Application No: FG/82/21/PL
Site Address: 11 Ferring Marine Ferring BN12 5PP
Description of works: Variation of condition imposed under FG/127/19/HH relating to approved plans.

Thank you for your internet representation made on 26th May 2021 which has been recorded as an objection with the comments as follows:

Proposed first floor at 1:100 @ A3

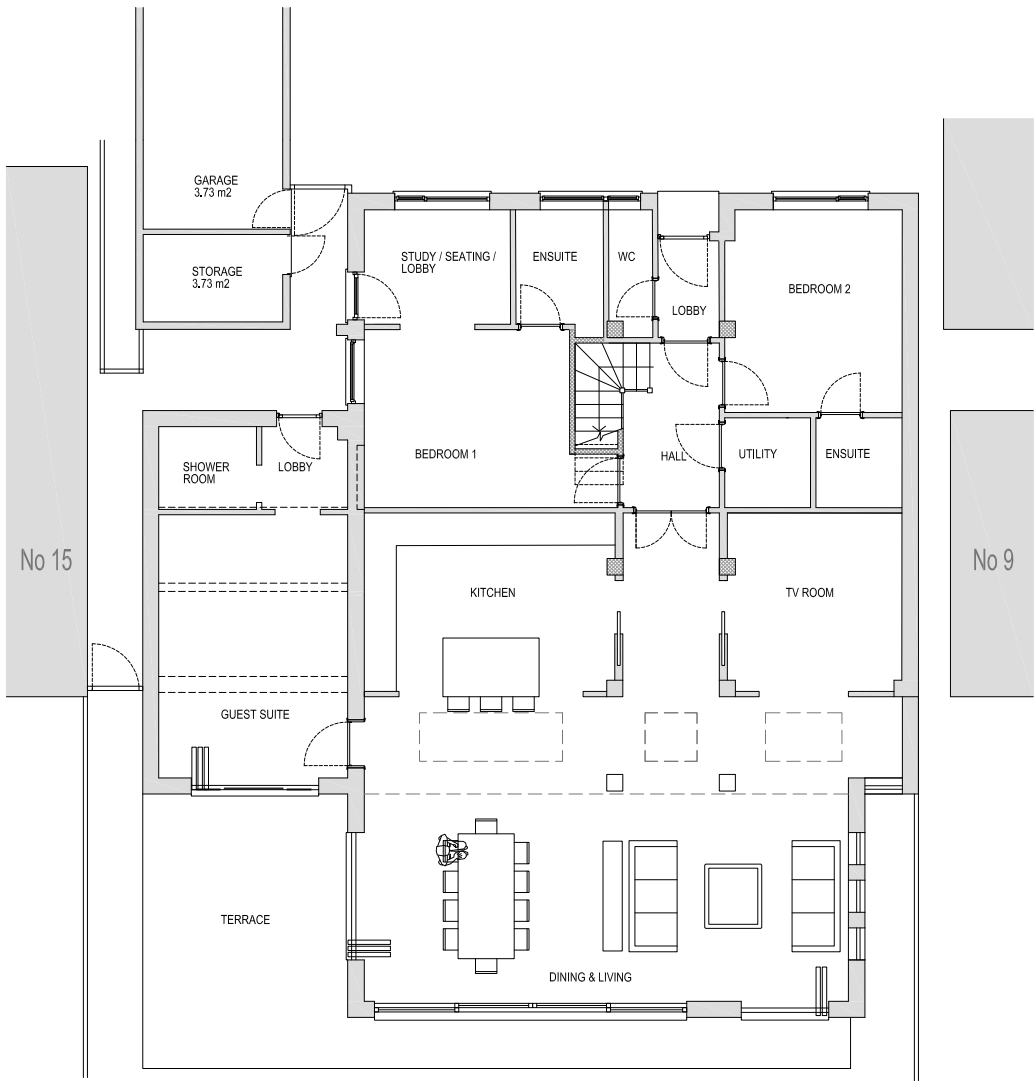
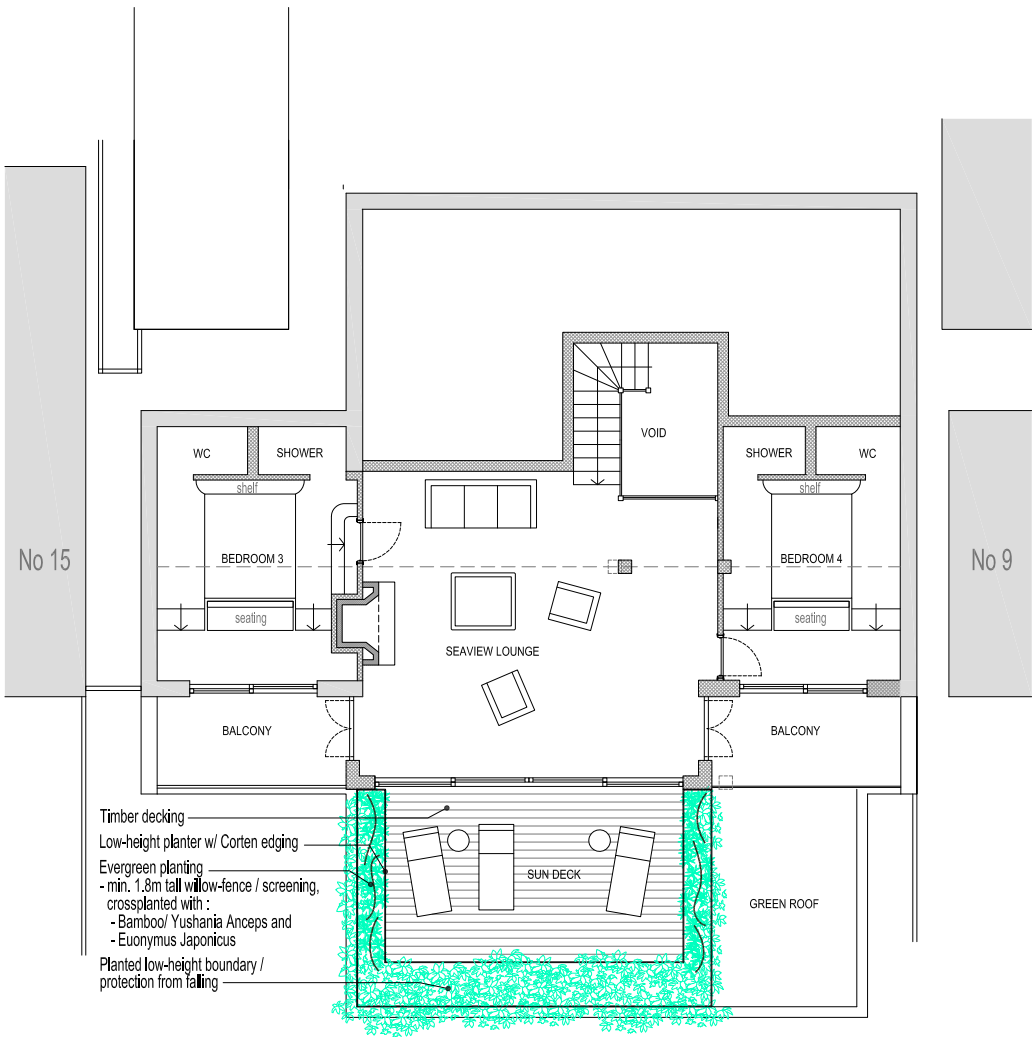
We object to the current balcony design as it does not give sufficient privacy to the neighbouring properties. It is not clear what the proposed depth of the balcony is from the plans but it appears to take up most of the 3m ground floor extension meaning that the overall structure is overbearing and impacts the light of the adjacent properties. Given its scale the balcony as proposed will enable direct viewing not only into the neighbouring properties but into those well beyond. The proximity of the balcony to the southern boundary means usage will impact the privacy of those on Patterson's walk and the beach. The temporary nature of the proposed balcony screening is clearly insufficient.
